PLANNING AMENDMENT

Application No. *H18/0227/02/A3*
 Date Registered **12 JUN 2002**
 Case Officer *T-G*

LAND OFF CHURCH GATE, SUPRA BRIDGE, LINCS

*ERECTION OF SEVEN HOUSES
 AND GARAGES.*

PLOTS 2 & 3
FLOOR PLANS & ELEVATIONS.

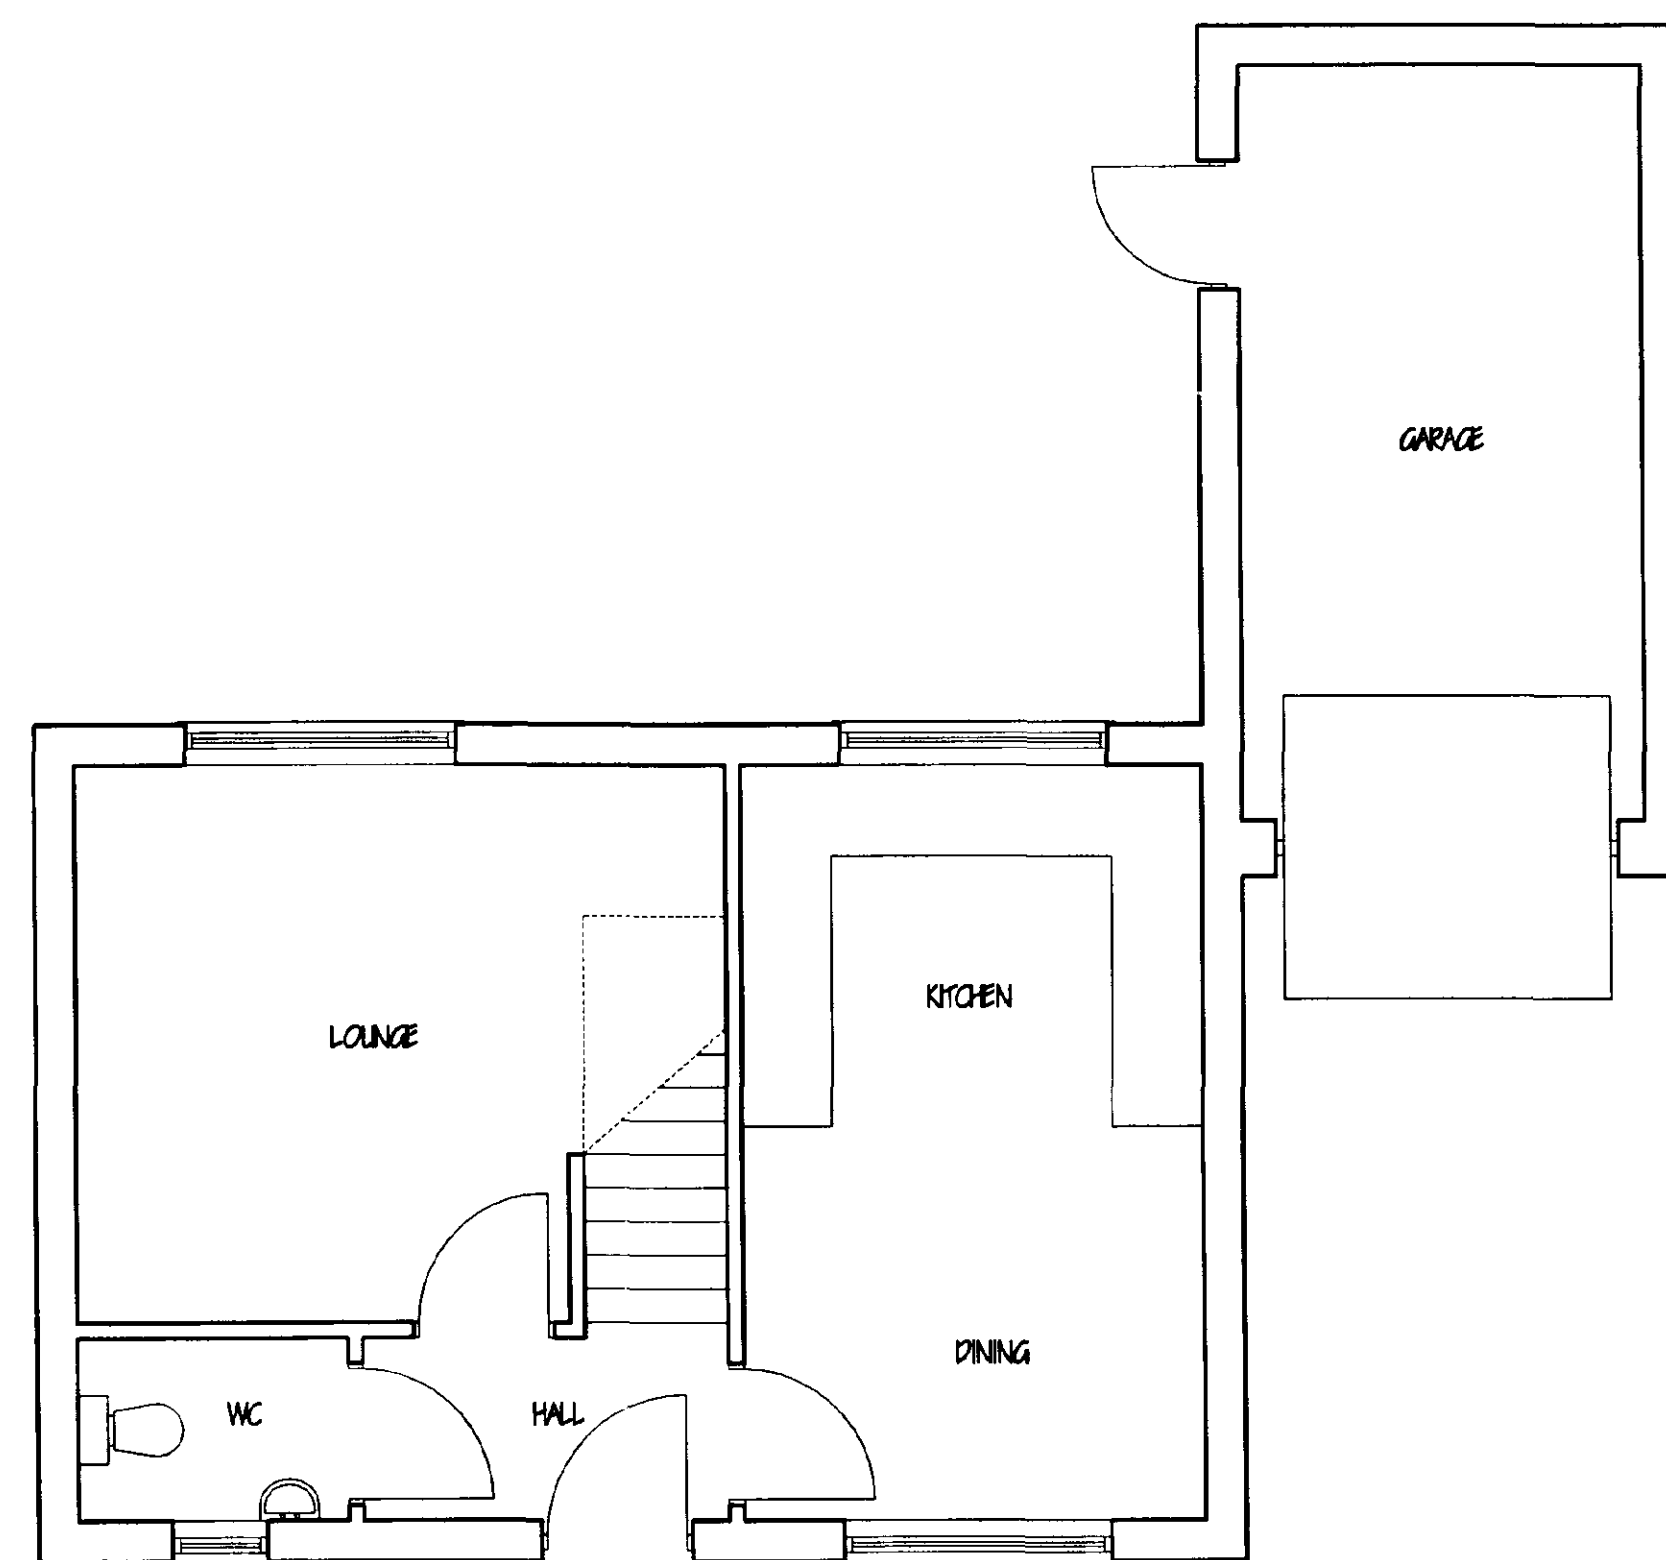
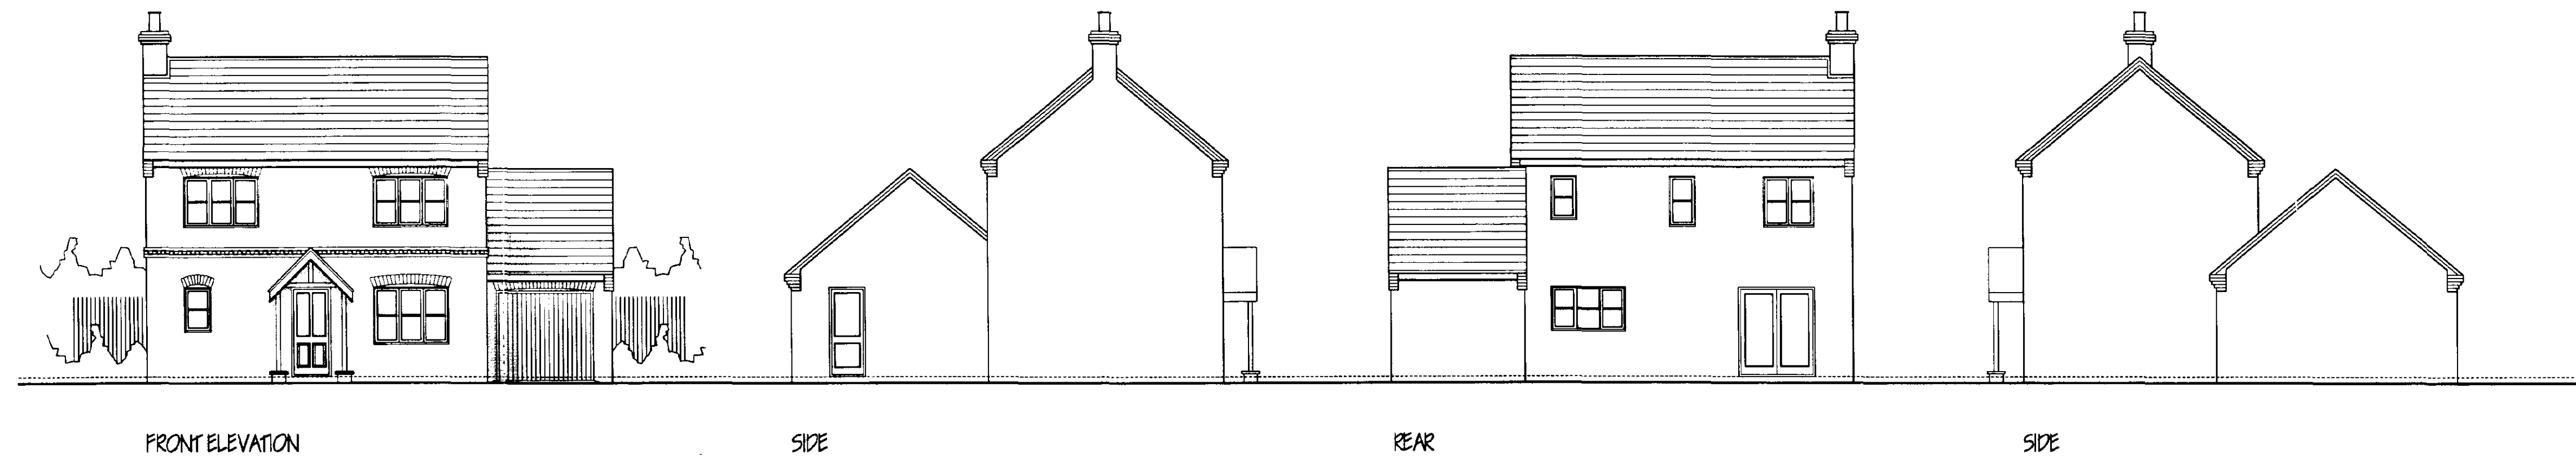
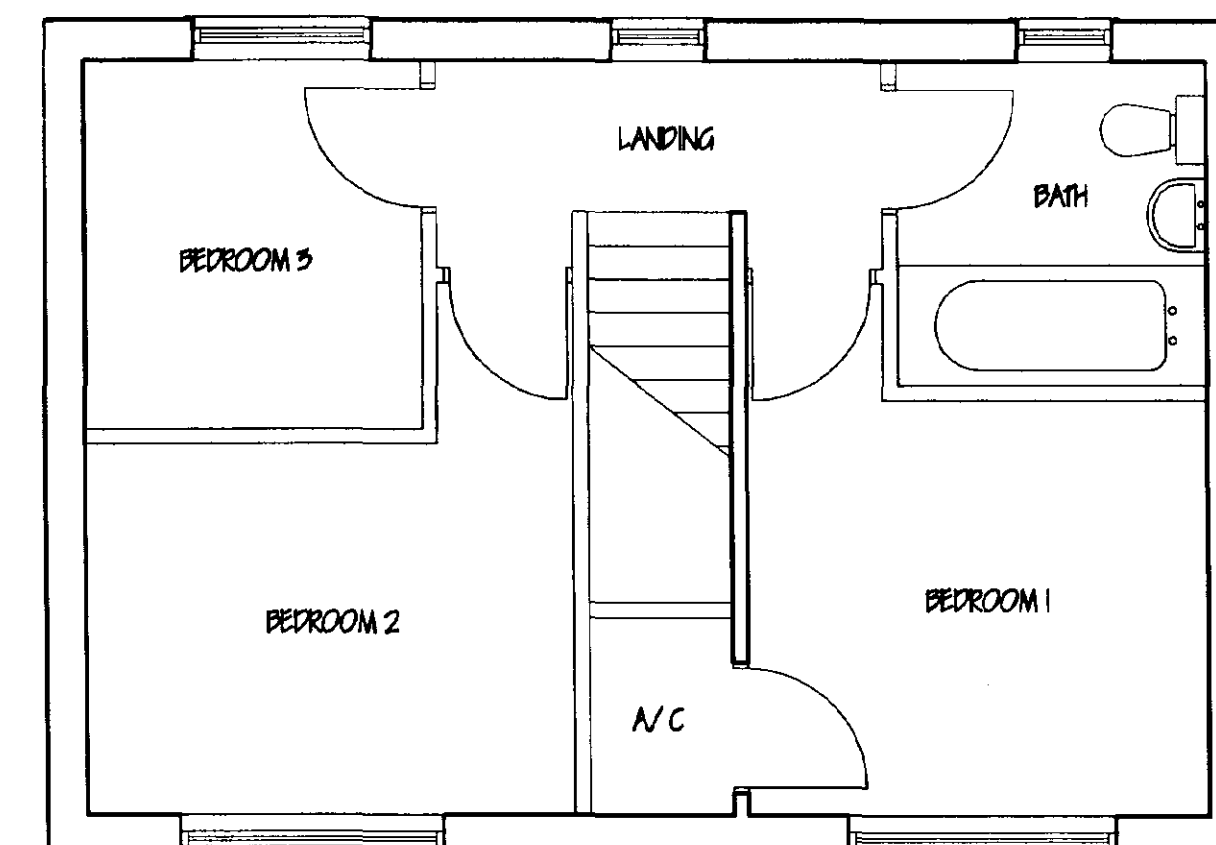
WINDOW RE-POSITIONING
ON PLOTS 2 + 3 TO
BEDROOM 3.

Further to your recent telephone conversation with Mr Russ Delahoy, regarding the above. I enclose revised floor plans and elevations for plots 2 & 3 incorporating window re-positioning to bedroom 3, as discussed.

Amendment: Window re-positioning on plots 2 & 3 to bedroom 3
Dwg no. 01.047/03B
